From: Kathryn Welch [REDACTED]
Sent: 19 November 2018 13:09
To: Sian Eggington
Subject: RE: Further Information Required on Your Ref: PP-07421588 Our Ref: EP/166/18/HH
Attachments: 18075 DOYLE 100 Sea Road East Preston-02R2 PROPOSED A1.pdf

From: Sian Eggington [REDACTED]
Sent: 15 November 2018 15:28
To: Kathryn Welch
Subject: Further Information Required on Your Ref: PP-07421588 Our Ref: EP/166/18/HH

**Sian Eggington
Planning Team**

Printed Date As Shown on A1
15/11/2018
Drawing Number 18075/02R2

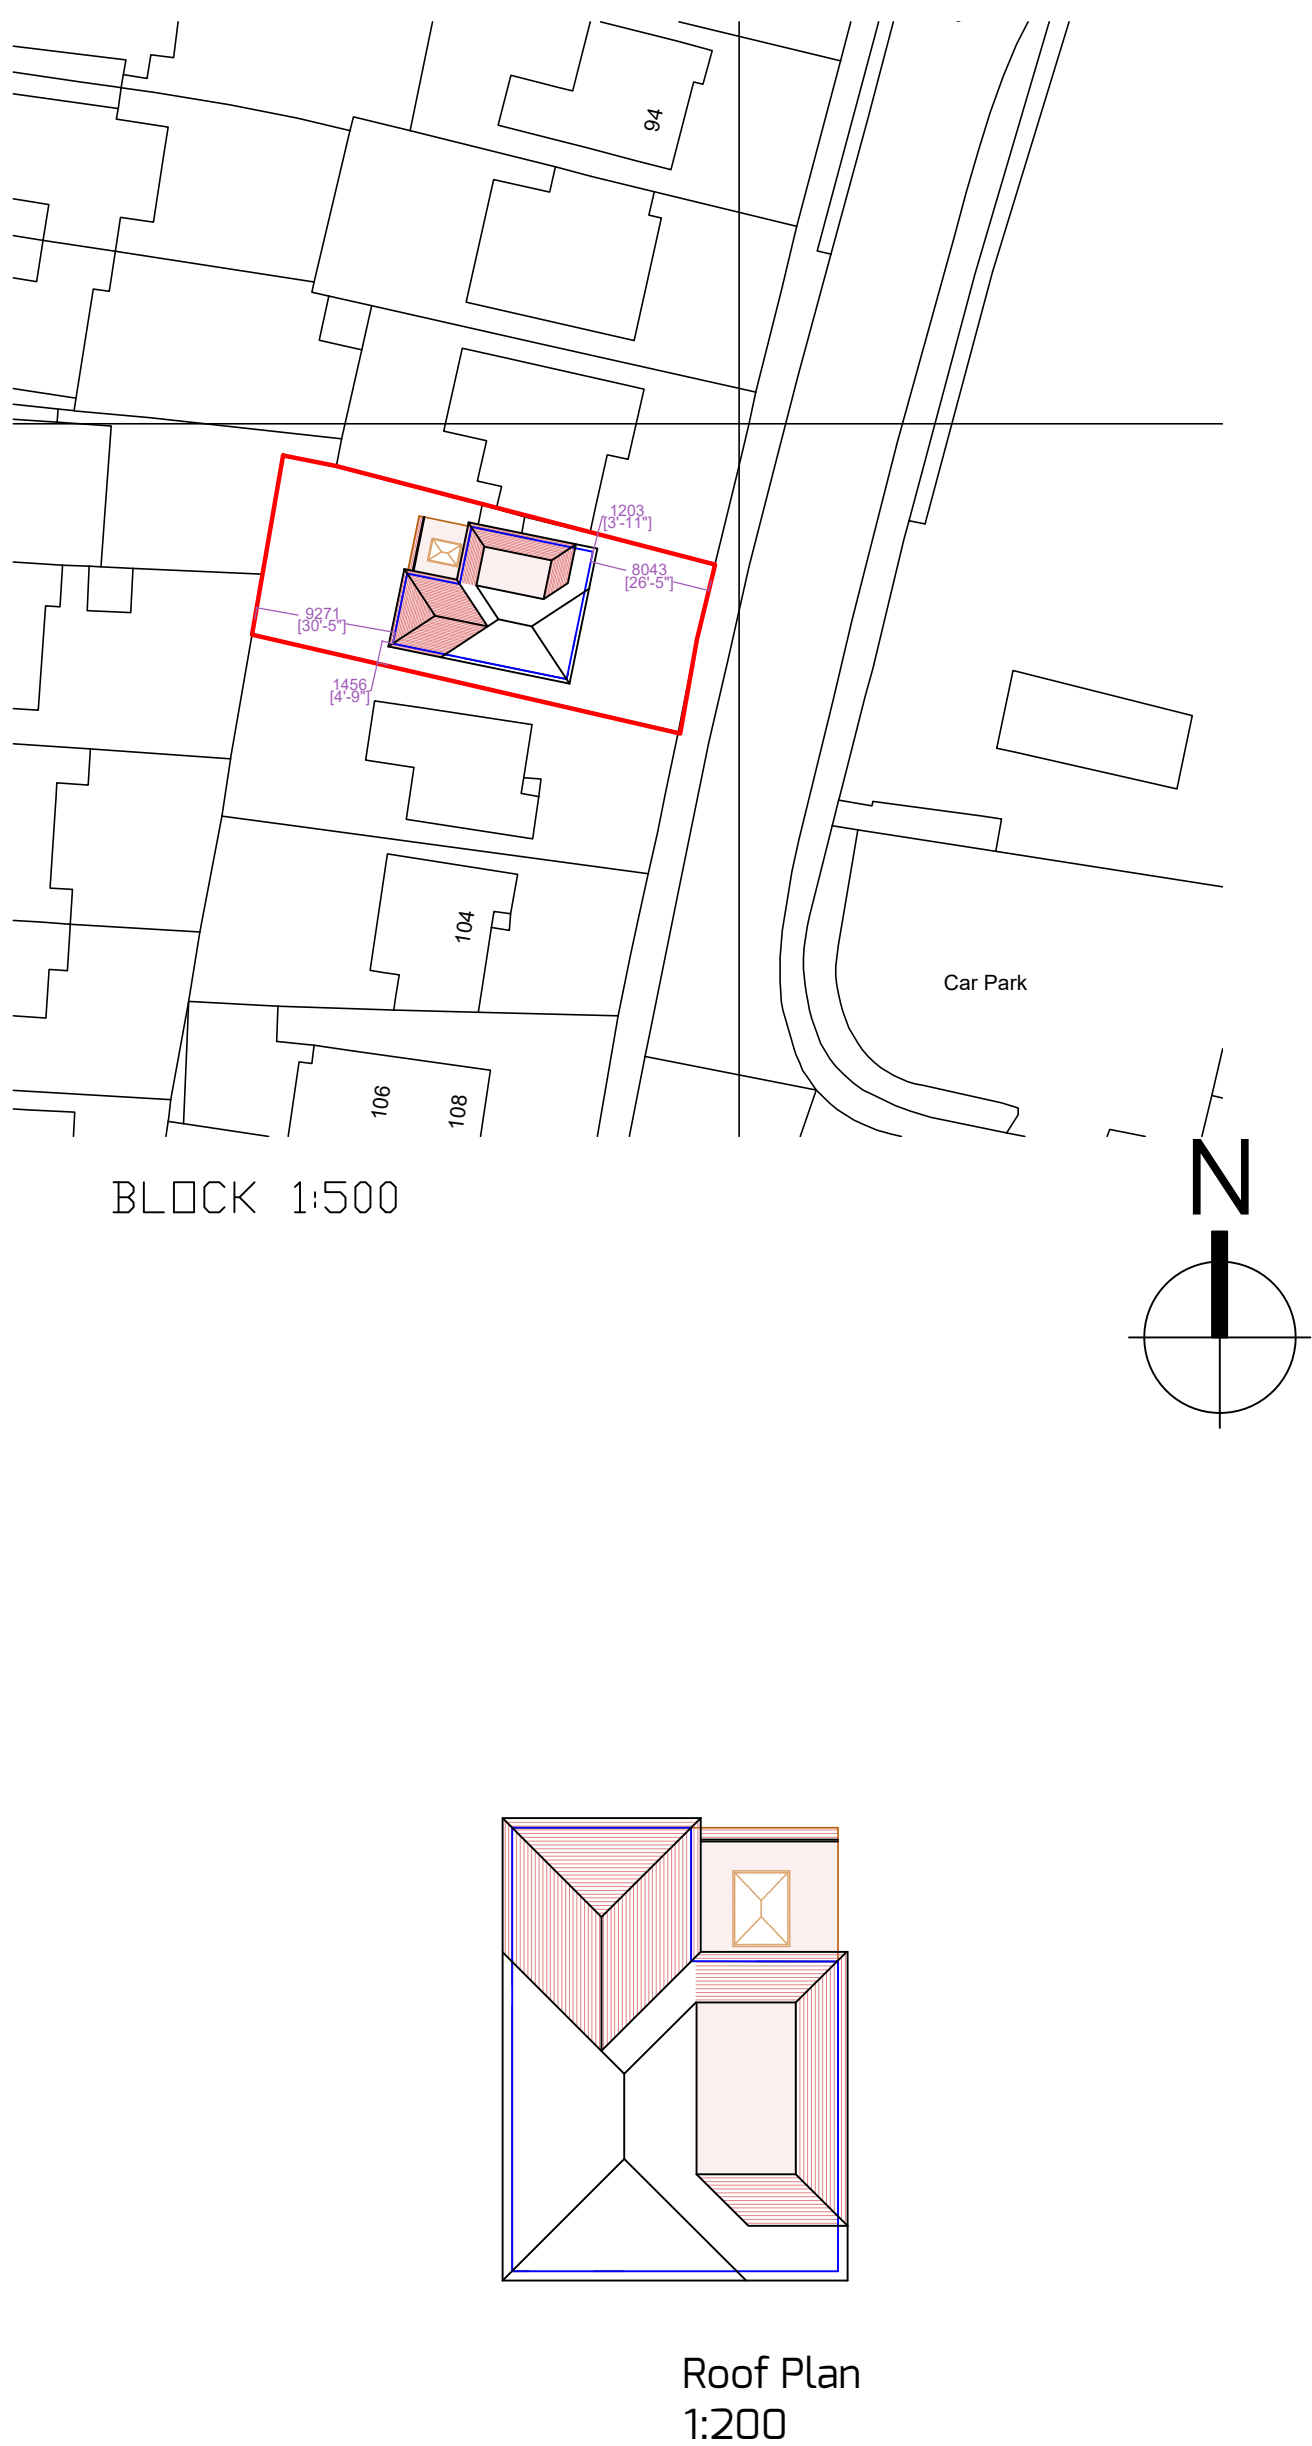
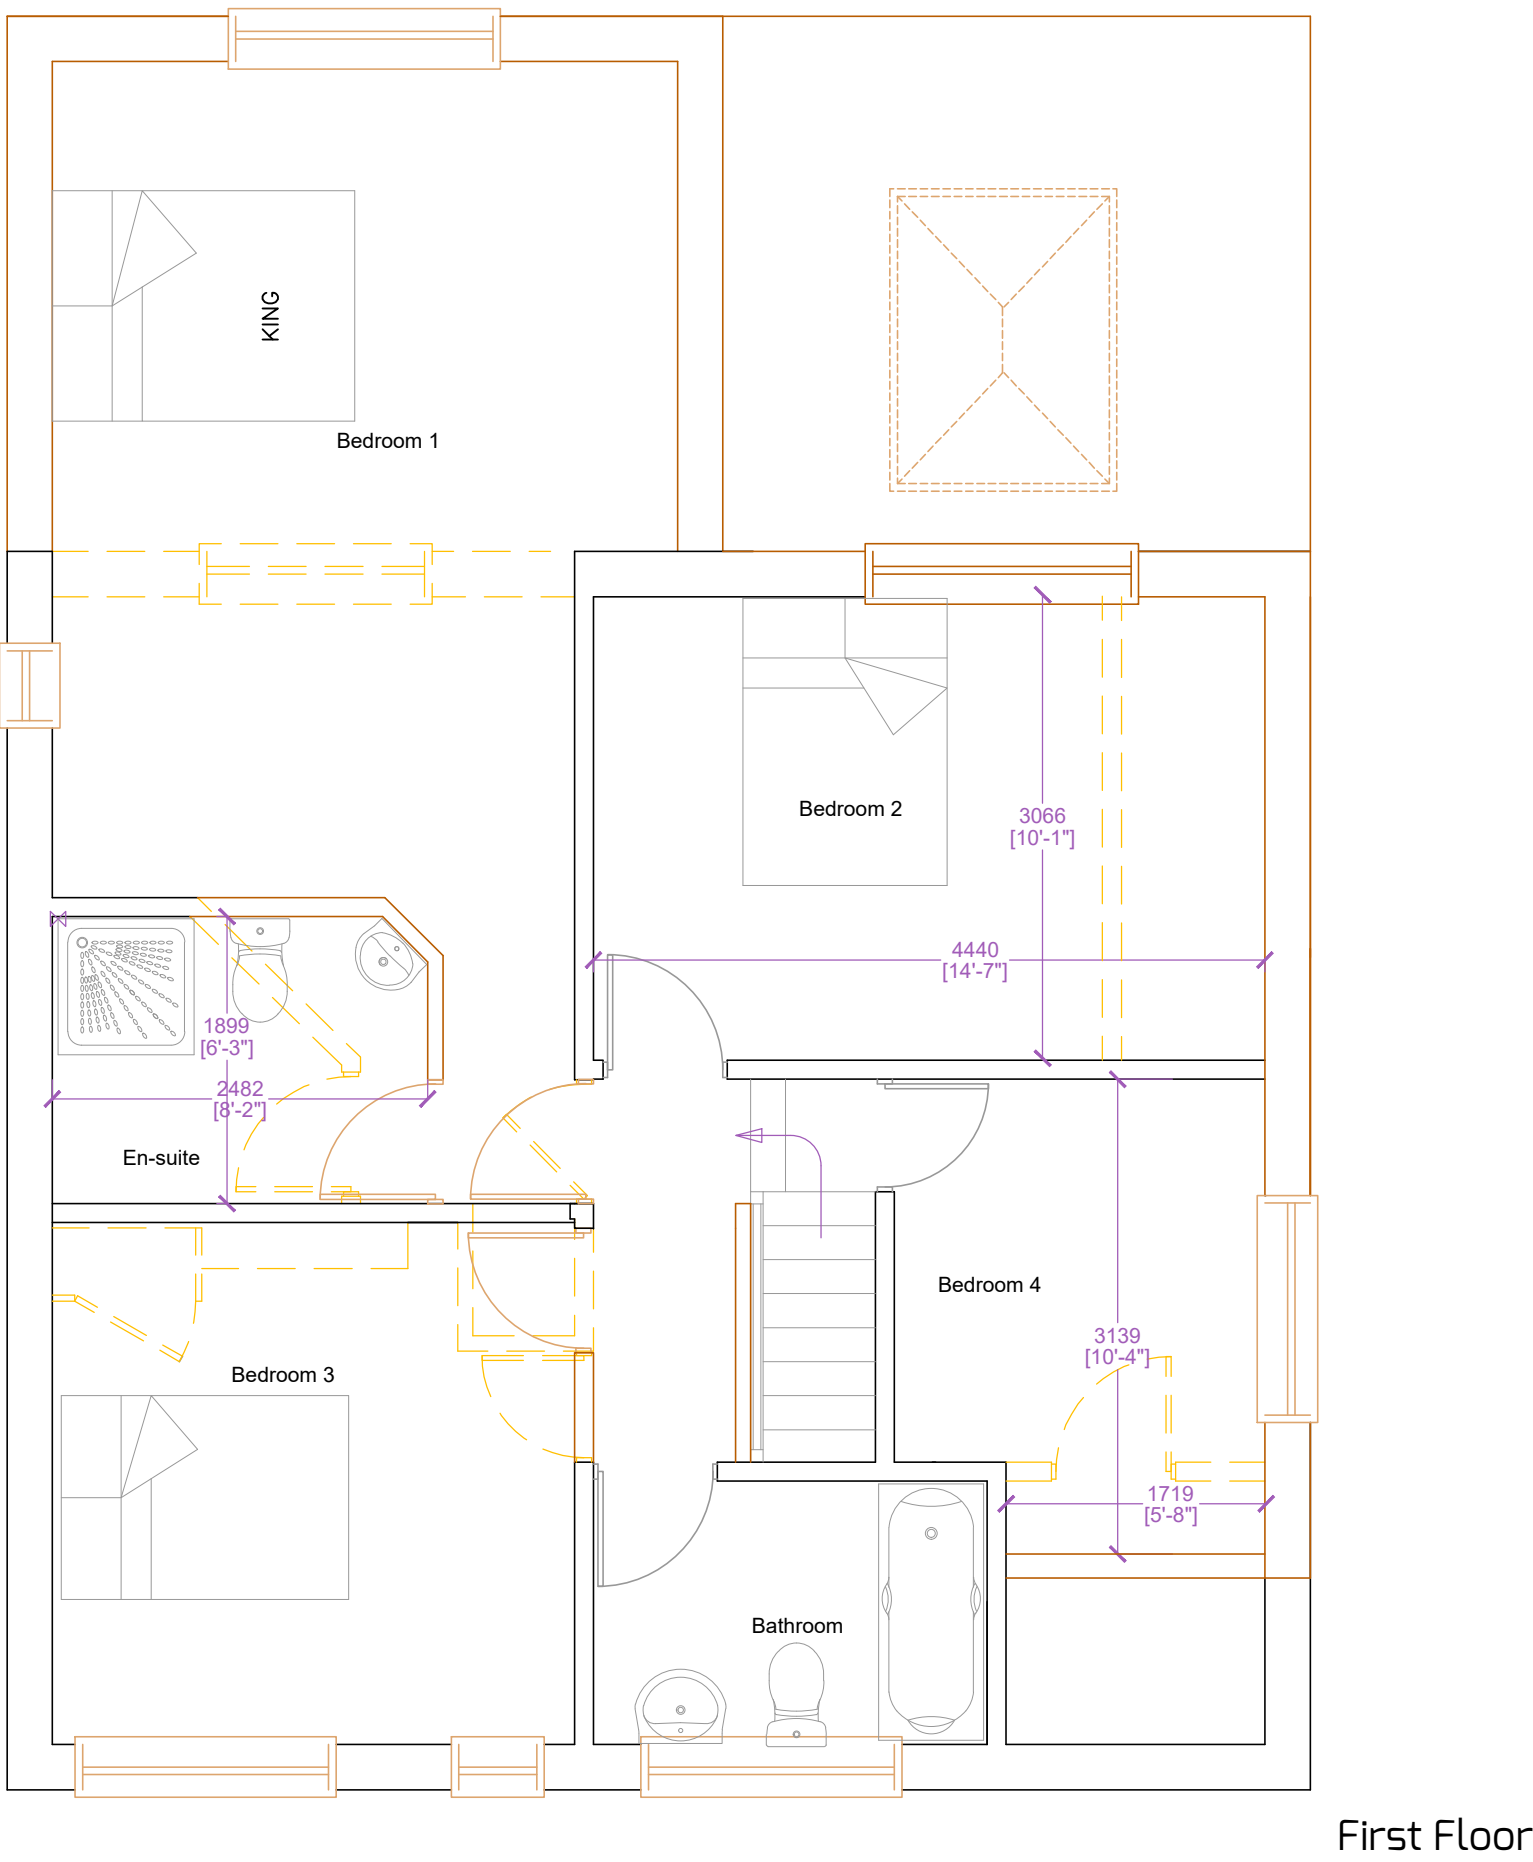
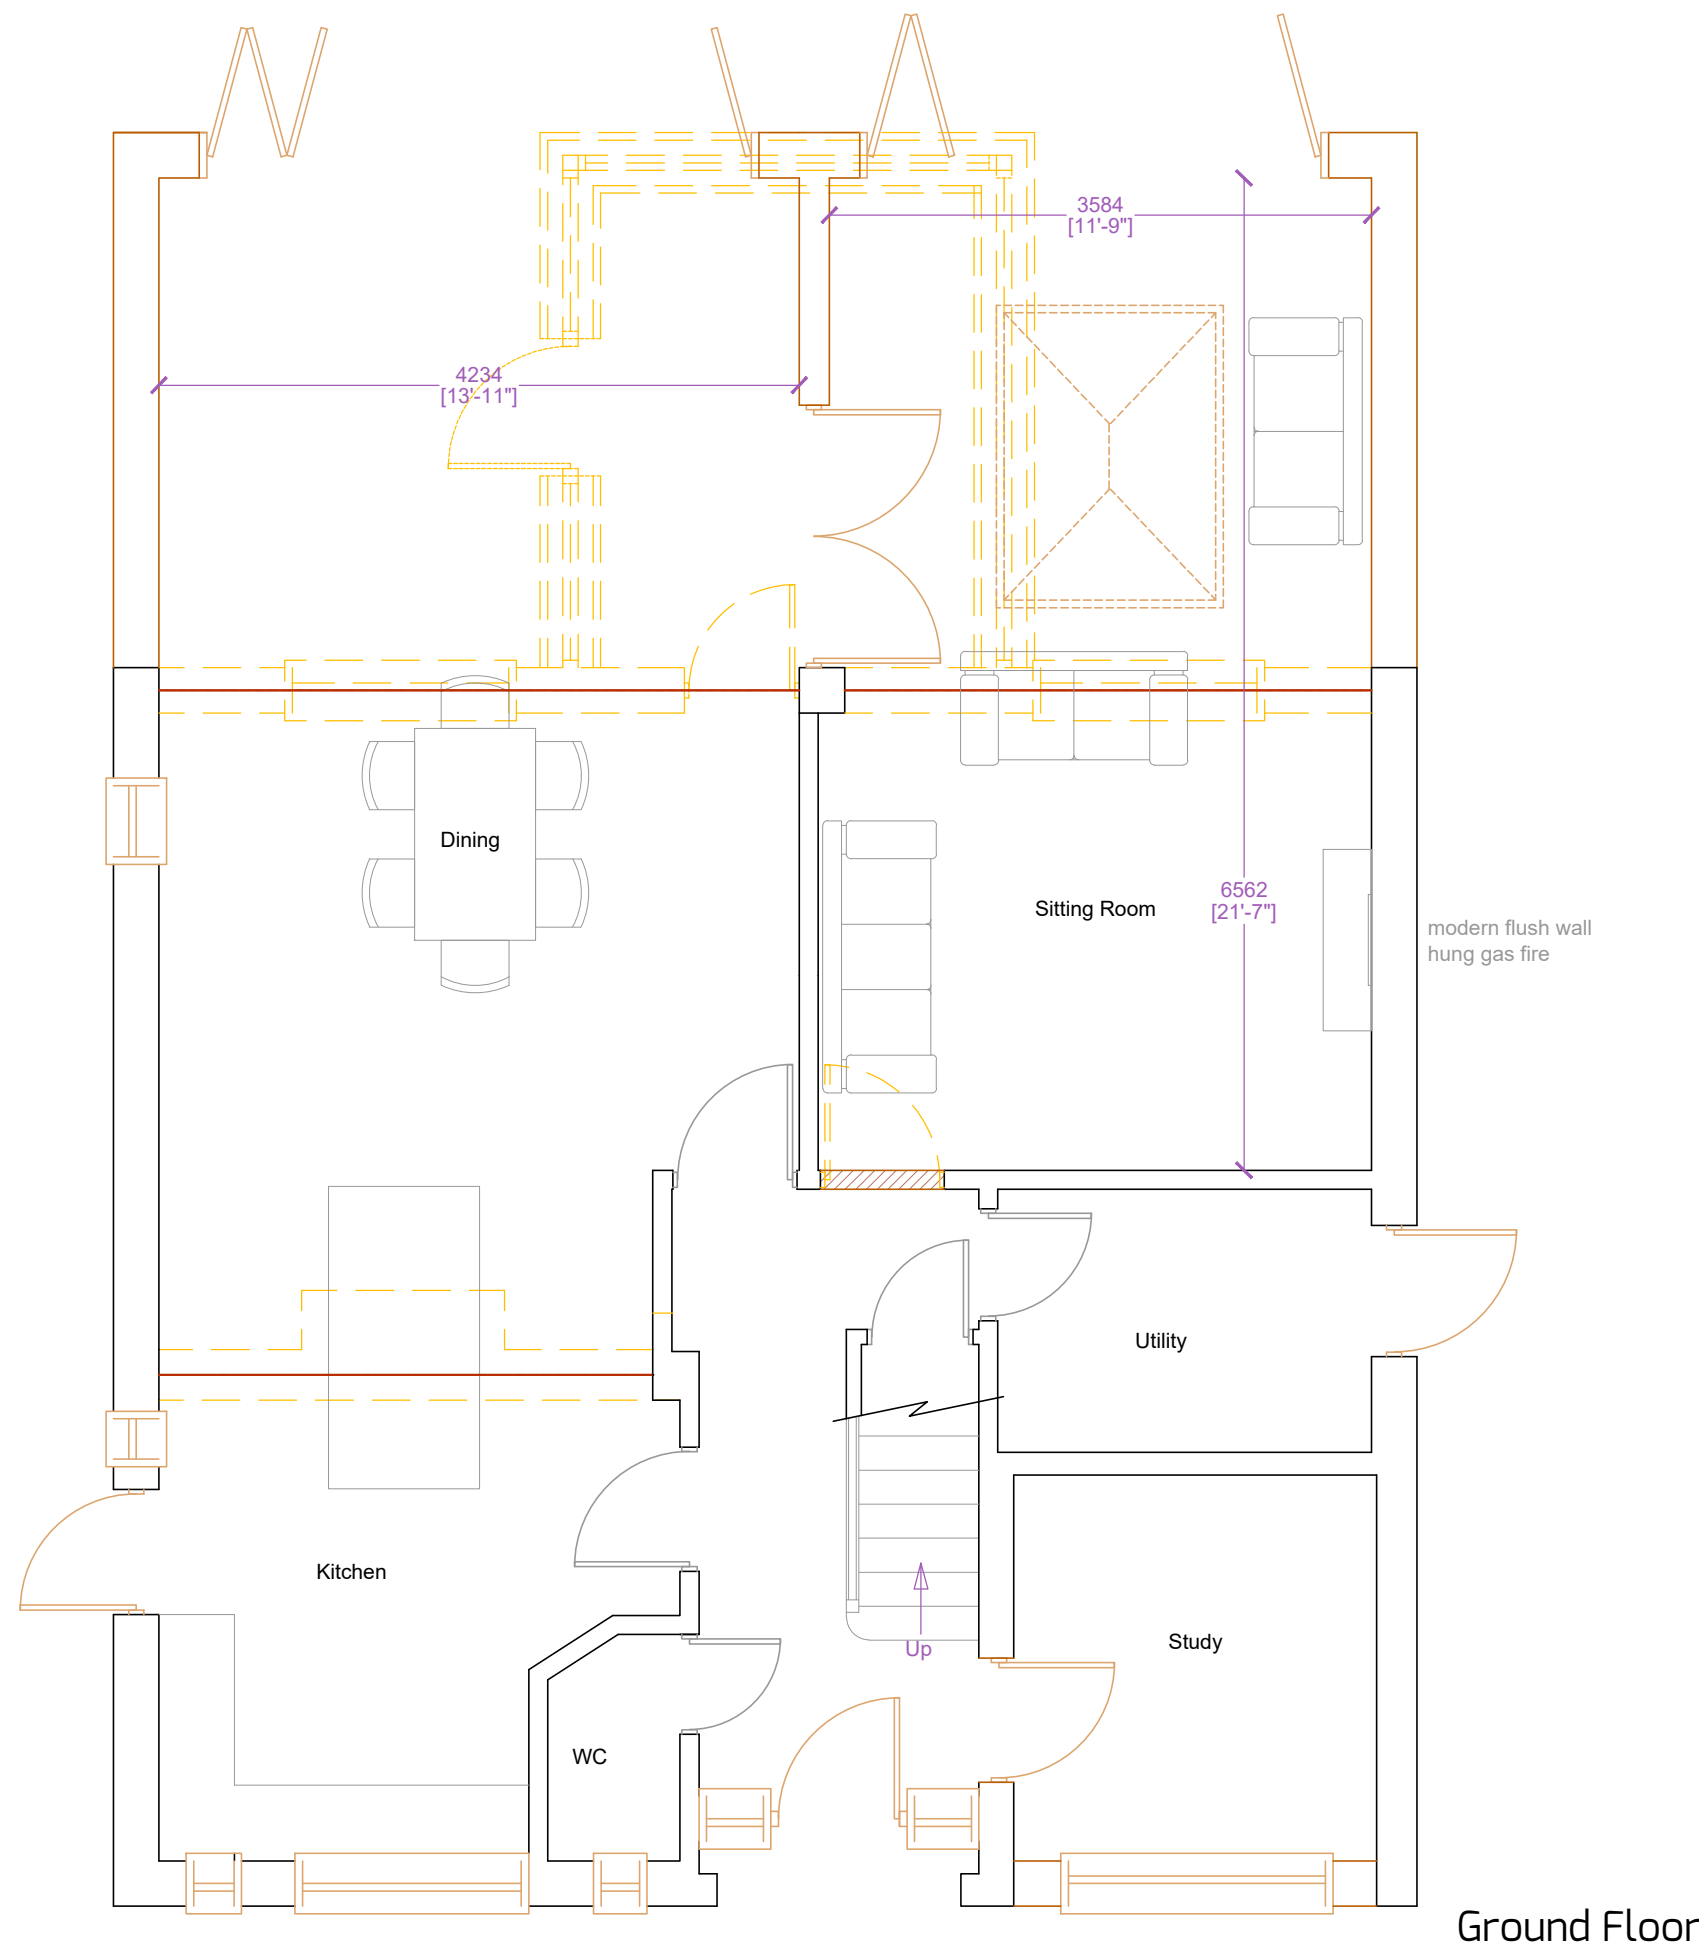
Thank you for your email. Please can a dimension be added on the block plan from the sides of the extension to the side boundaries. Once received I am happy to make the application valid and upload immediately.

Amended plans attached.
